**Parkes Hospital Redevelopment (SSD\_6107)  
Response to exhibition of Environmental Impact Statement**

### **Parkes Hospital Redevelopment (SSD\_6107) Response to exhibition of EIS Comments by Crown Lands**

1 PLAN
SITE PLAN
1:750

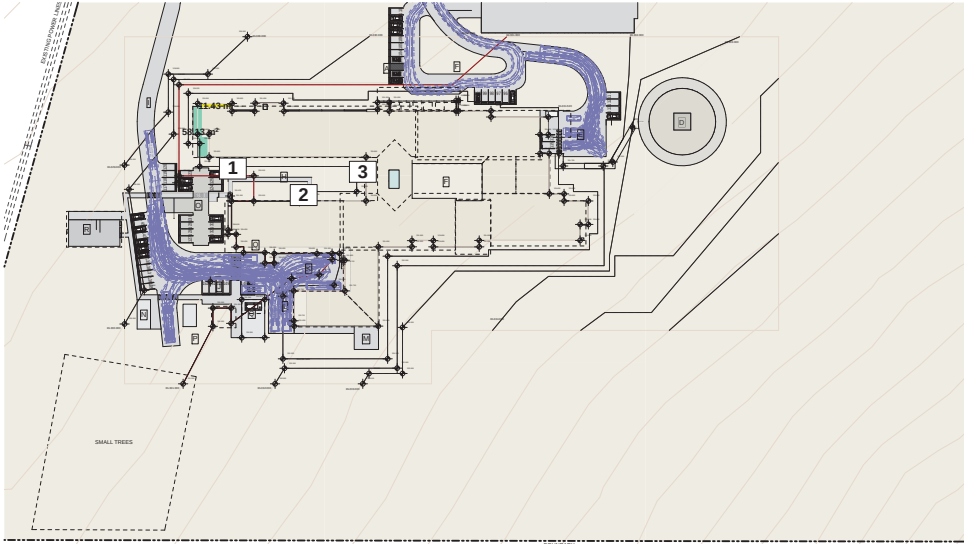
The EIS has indicated that development activities will only occur on Crown land Lot 550 DP 750179 and Part Lot 73713 DP 1447330 (south) with access being gained by a proposed ring road that would adjoin the Newell Highway to the north west of the site.

While not part of this Development Application, it is noted that the proposed ring road covers a wider area involving a large number of Crown land parcels which is currently held under Licence No 403569 by Parkes Shire Council. Lot 610 DP 750179, Part Lot 7313 DP 1147330 (north) which form part of the subject licence are located adjacent to the site (**Figure A**).

It is also noted that Crown land Lots 7022, 7009, 7076, 7075, 7010 DP 750179 are located adjacent to the Newell Highway and in the vicinity of the proposed site (see **Figure A**). These Lots form part of a Crown Reserve held for Future Public Requirements and are remnants of an historical camping and stock travelling reserve.

Crown Land recognises that the acquisition of Crown land Lot 550 DP 750179 and Part Lot 7313 DP 1147330 (south) is currently being progressed by Health Administration Corporation. If approval for development precedes the acquisition of land, the Applicant will need to consult with Crown Lands to determine access requirements.

If the ring road development occurs prior to construction of the current proposal as stated by Section 3.5 of the EIS, consultation with Crown Lands by the Parkes Shire Council and relevant road authorities will be required to determine the appropriate parcels of Crown Land to be acquired. It is unclear if Lot 610 DP 750179 and Part Lot 7313 DP 1147330 (north) would be acquired for the purposes of future expansion of the hospital and the ring road respectively.

If this is not the case, and as Lot 610 DP 750179 and Lot 73713 DP 1147330 (north) has the potential to be directly impacted by overflow activities from the construction and operation of the Hospital, further information is required by the Applicant on what mitigation measures would be adopted to ensure that offsite vehicle parking and storing of construction material does not occur. This does not in any way authorise use of Crown land by the proposal.

Additionally, as described in Section 5.6.7 of the EIS, a walking and cycling path adjacent to the proposed Hospital and the Newell Highway would also provide access to the site. Consultation by Parkes Shire Council and other relevant road authorities is required with Crown Lands to determine the most appropriate pathway for the acquisition of Crown land Lots 7022, 7009, 7076, 7075, 7010 DP 750179 to allow the continuation for use of these areas by the public.
